PLANNING AND COMMUNITY DEVELOPMENT DEPARTMENT
CRAIG DOSSEY, EXECUTIVE DIRECTOR

Subject: D 49 Exemption Ex-17-001, Review 1

LAND SURVEY PLAT

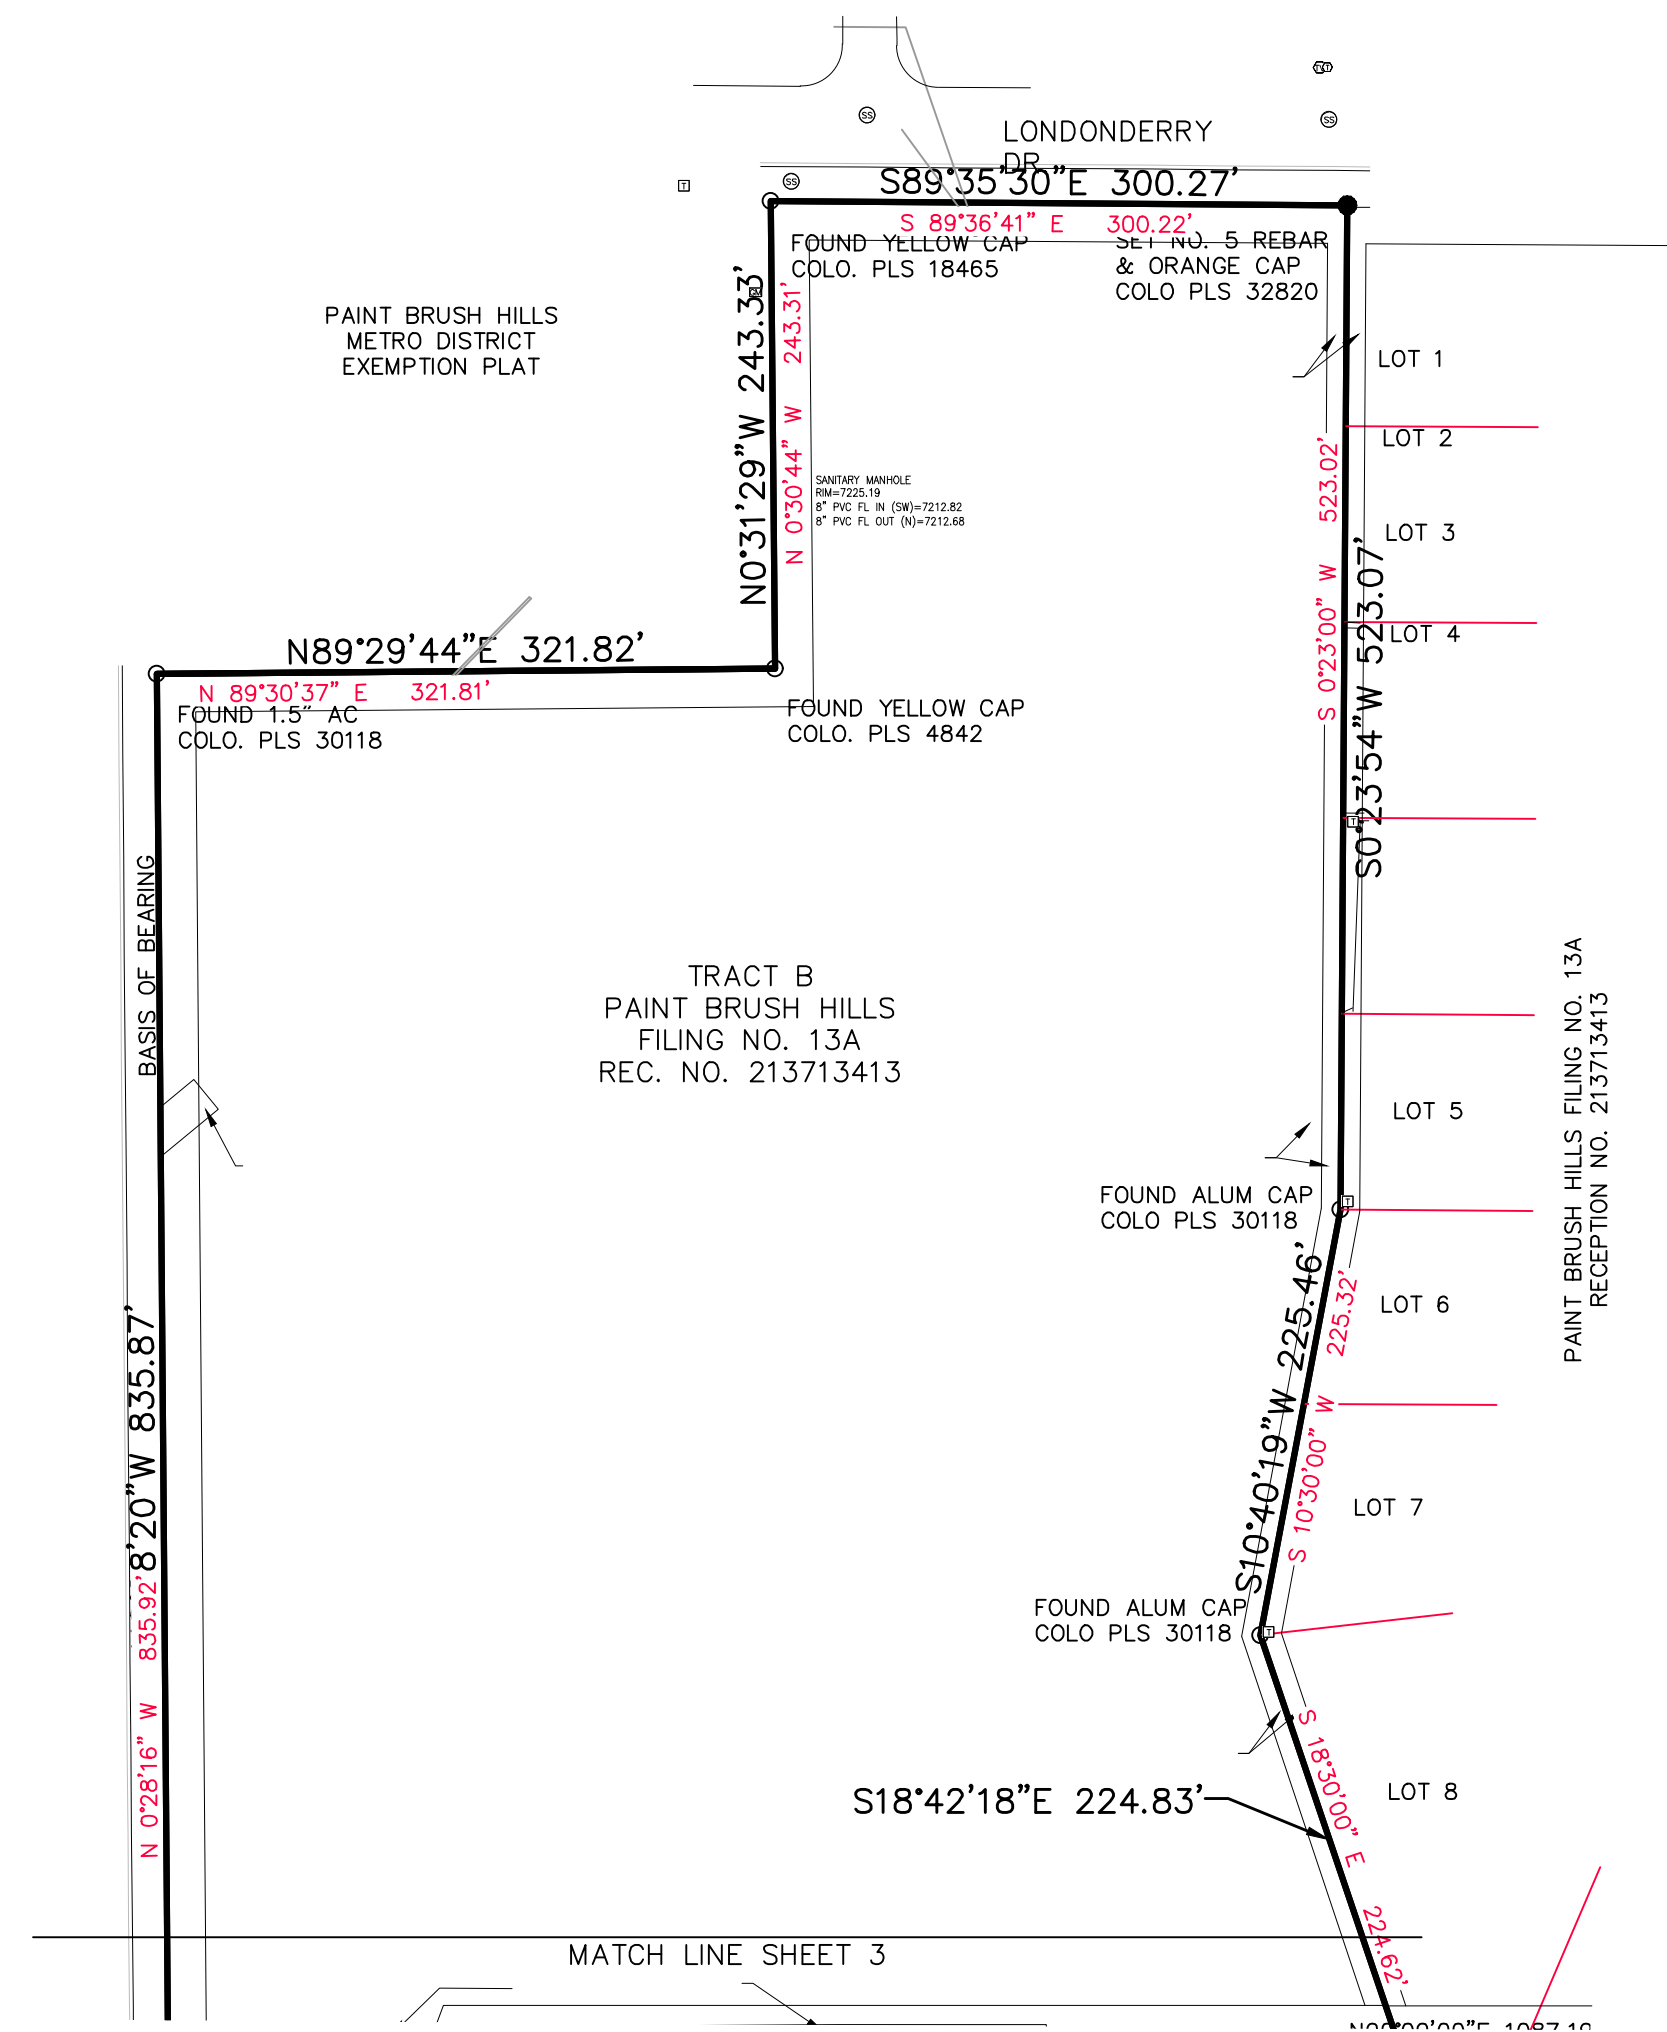
1. The drawing as submitted does not show that the two parcels are to become one parcel. Please revise drawings to show the as existing and as proposed condition. **SEPARATE GRAPHICS SHOWN.**
